APPROVED
 Limited building only review
 Permit holder responsible for full compliance with the code

02/18/2021

Drawing file: BRES2010-0062 / Approved 2x updated 12 Overby Ct..pdf

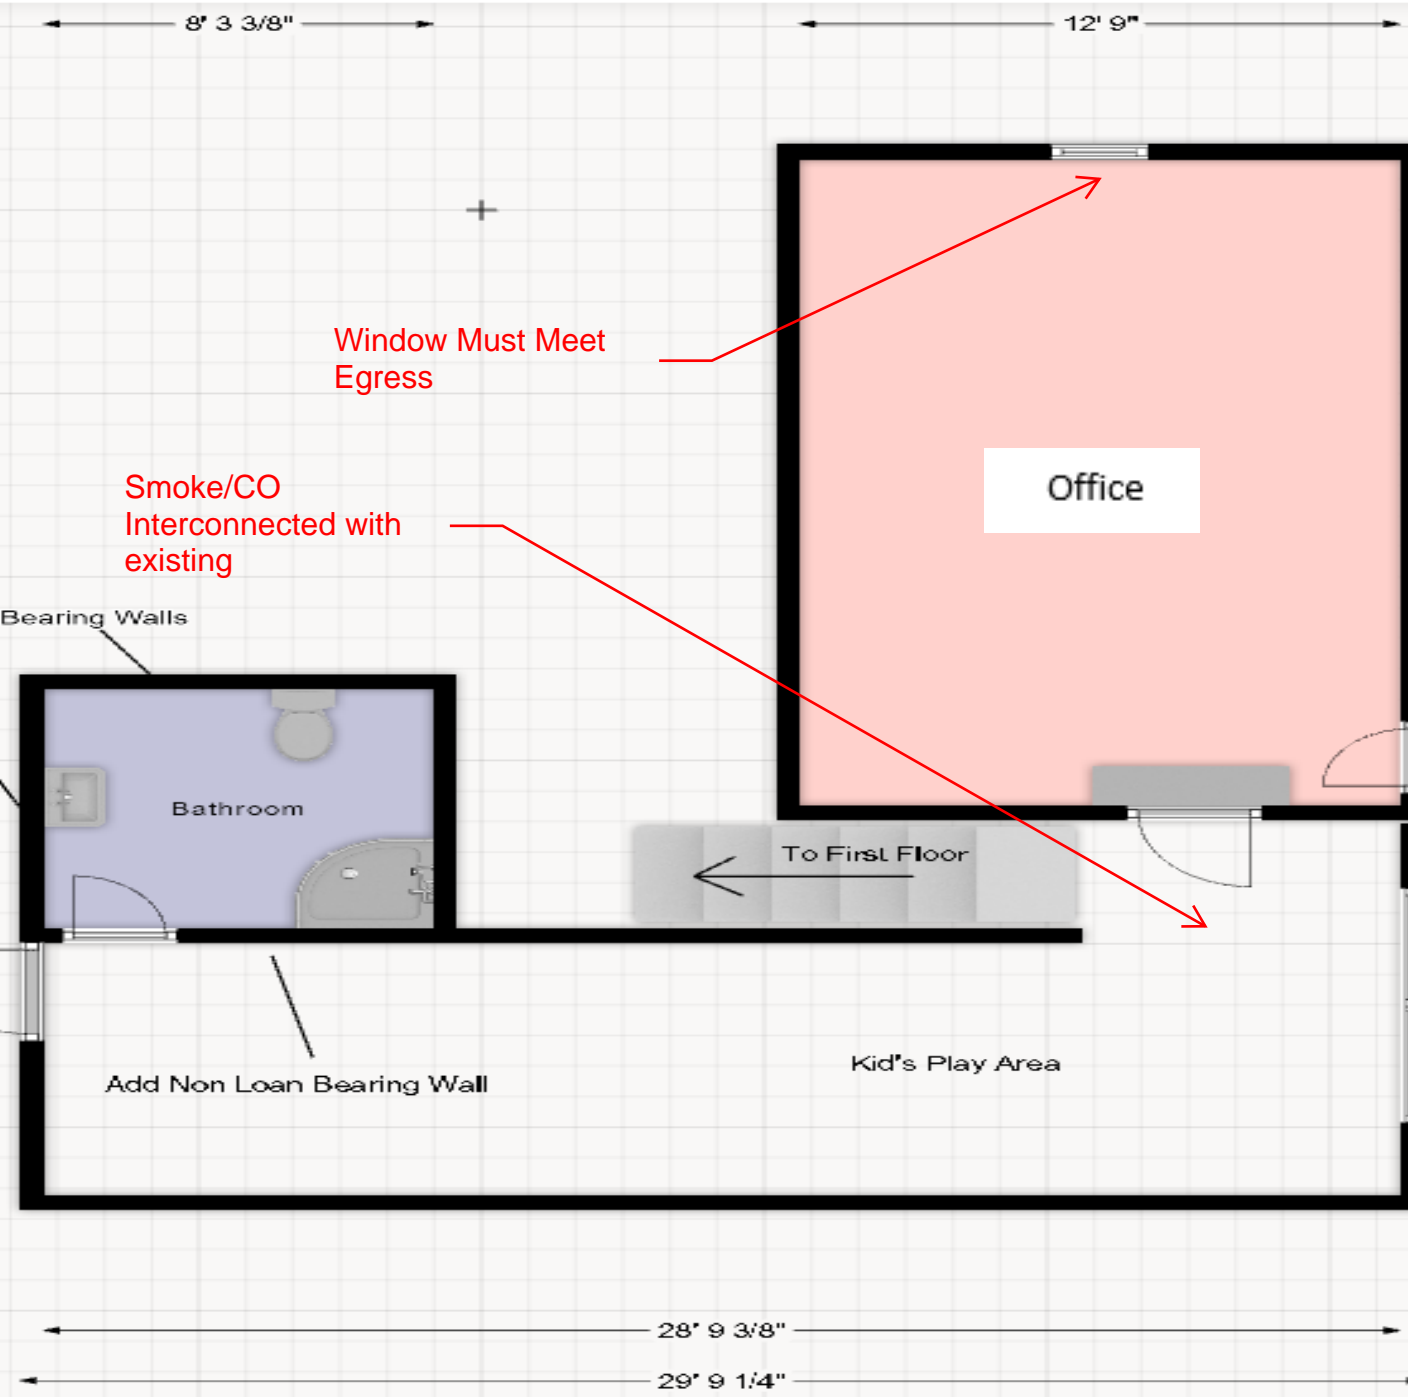
Window must meet egress

Smoke/CO detector tied in w/ existing downstairs
